STATEMENT OF ENVIRONMENTAL EFFECTS: SECTION 75W APPLICATION TO MAJOR PROJECT APPLICATION NO. 10_0177 STAGE 1 AT 14-18 BOONDAH ROAD, WARRIEWOOD (LOT 20, DP 1080979) TO VARY CONDITION A1 - CHILDCARE POOL PLANS & ELEVATIONS

Pursuant to Section 75W(1)(a) of the Environmental Planning and Assessment Act, 1979, a "Modification of Approval" is sought to vary Condition A1 of Project Approval, MP10_0177, 'Development in Accordance with Plans and Documentation'. The amendment is sought to rectify the ground Relative Level (RL) due to a notation error on the plans for the swimming pool building.

CHILDCARE-POOL PLANS & ELEVS
SCALE 1:200

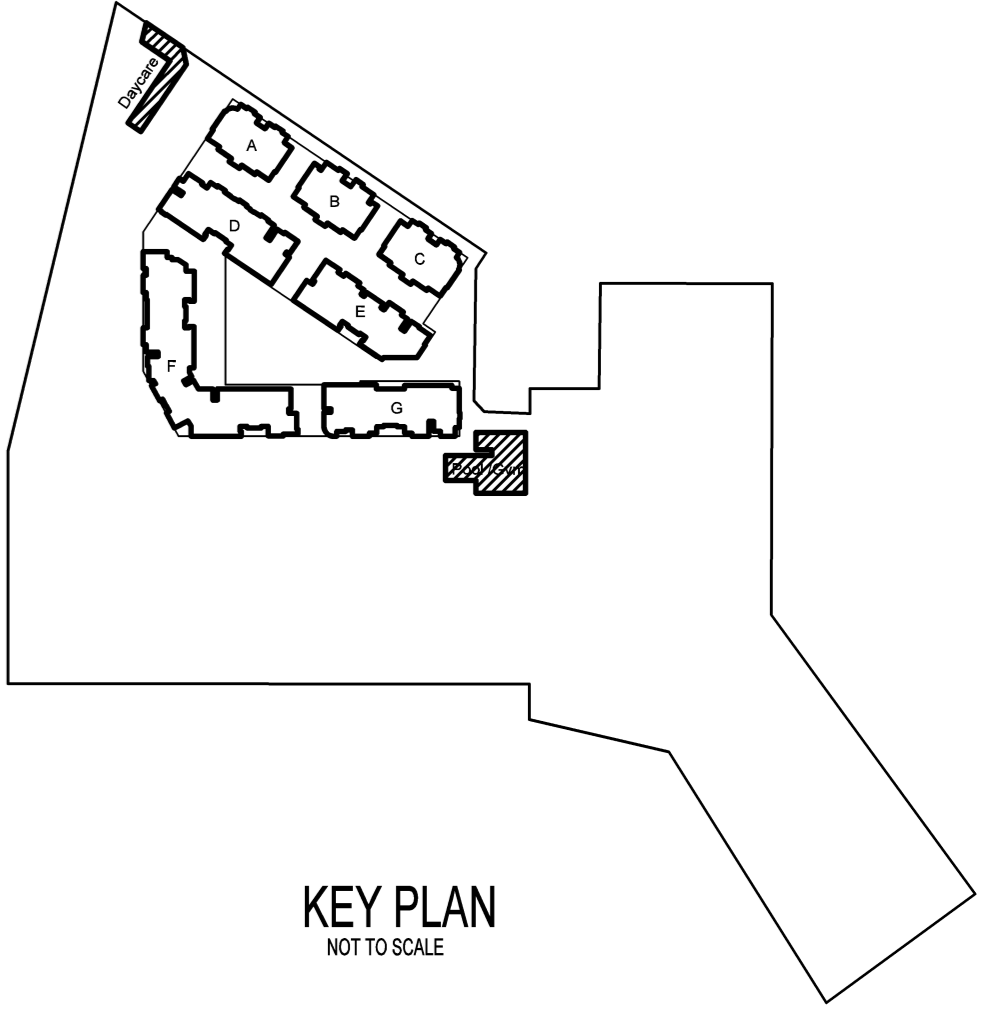
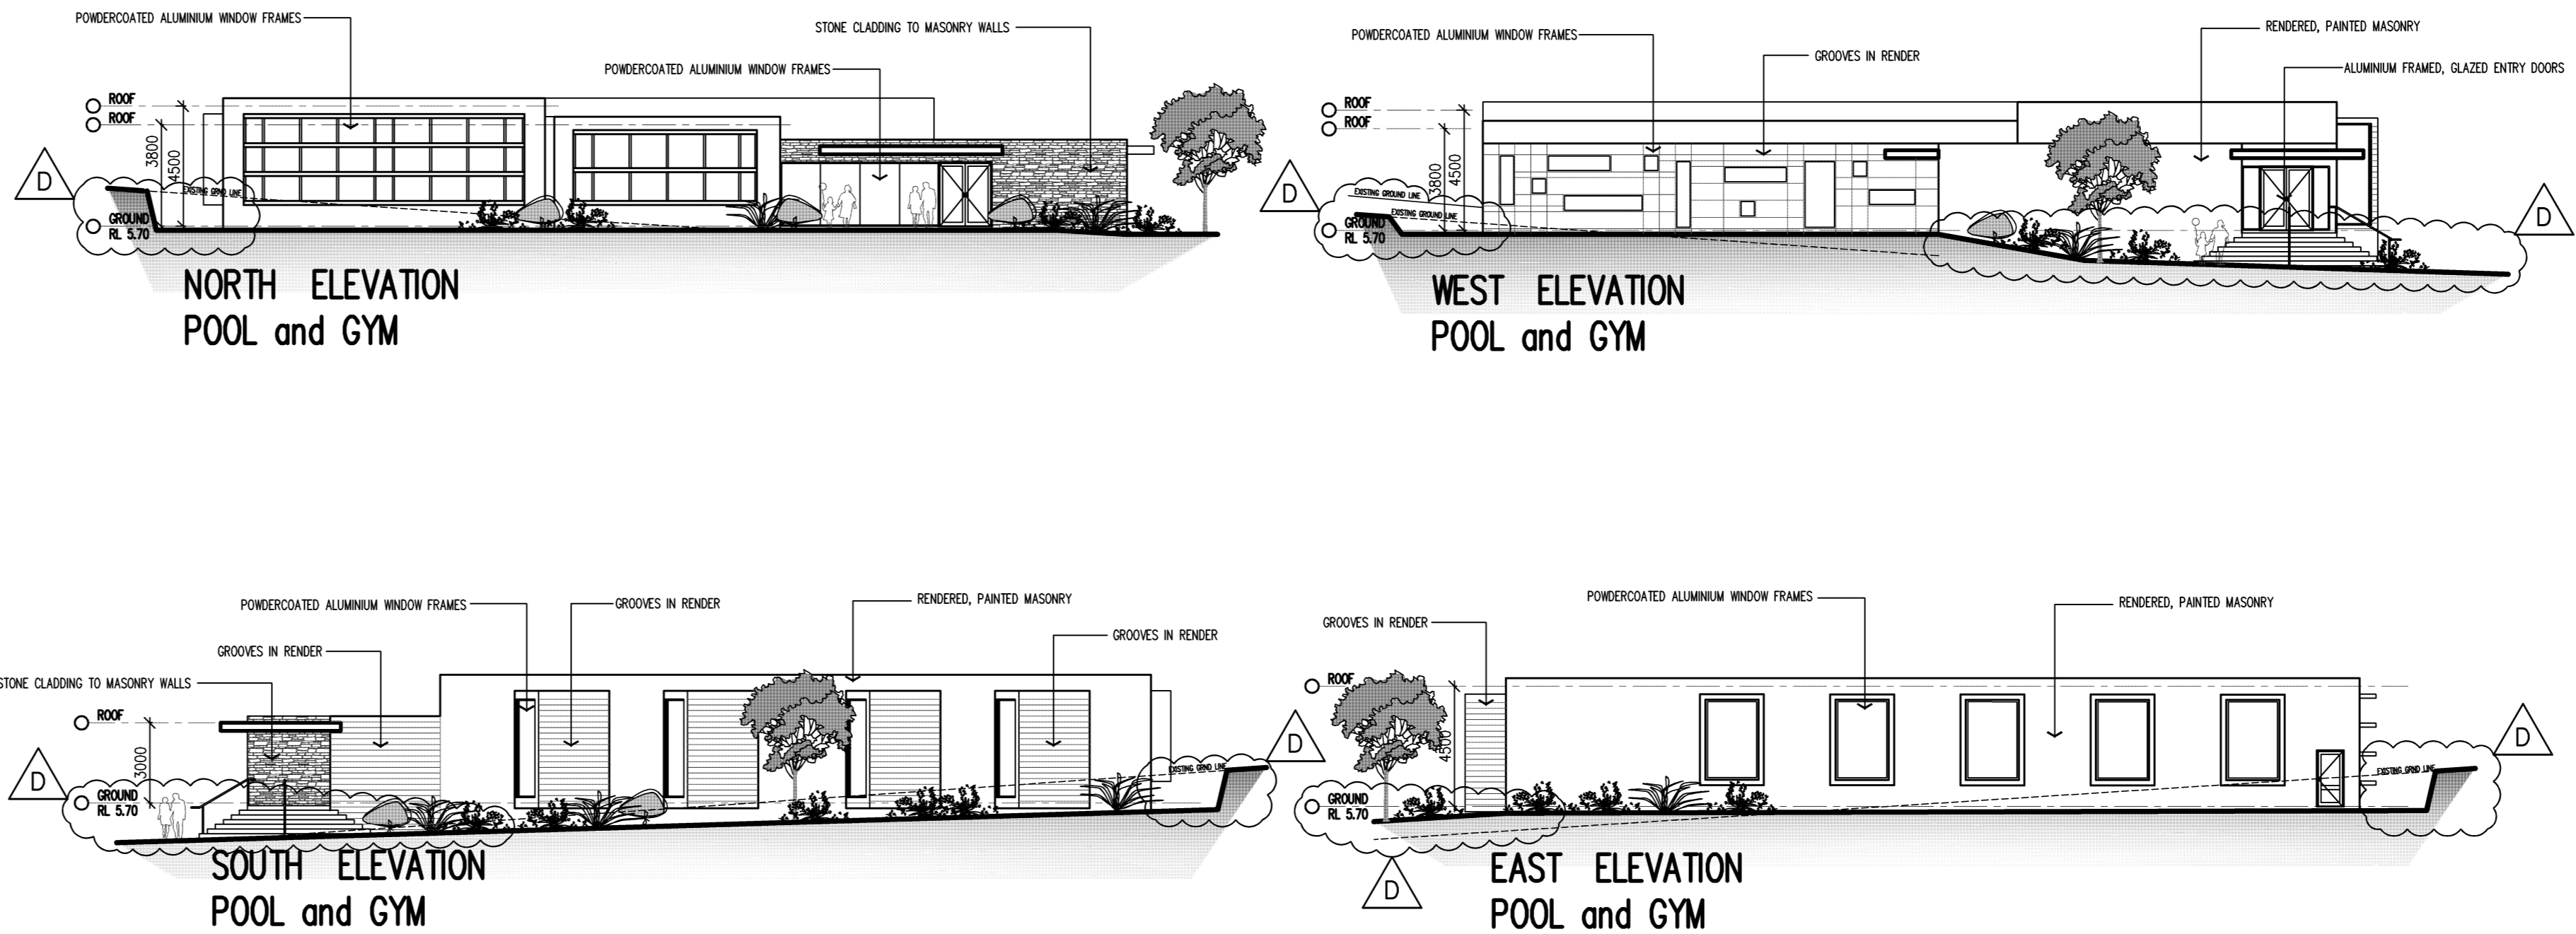
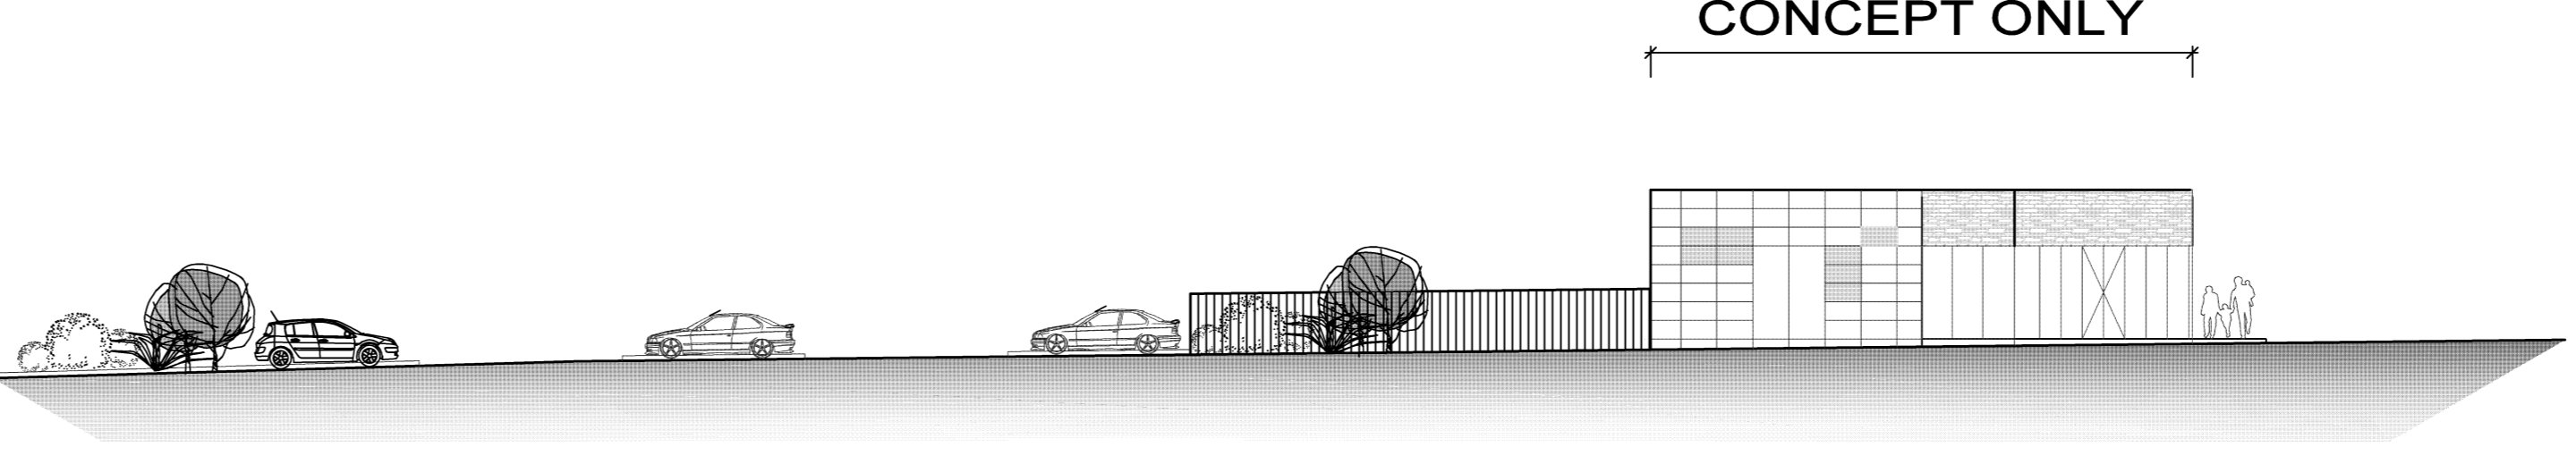
The original approval identified the ground RL at 5.00. The RL should read as 5.70, otherwise part of the building will be underground, which creates long term structural problems. Condition A1 should therefore be amended as follows:

The modification is in response to a drafting error on the original plans. This will enable the building to be accessed on a level gradient and ensure that the building is not below ground at any point. This minor adjustment ensures that the building can be constructed and maintained appropriately.

Architectural Plans				
Drawing No.	Revision	Name of Plan	Drawn By	Date
DA30	G	Childcare Pool Plans & Elevations	Meriton Apartments Pty Ltd	07.03.11
DA30	D	Childcare Pool Plans & Elevations	Meriton Apartments Pty Ltd	20.06.12
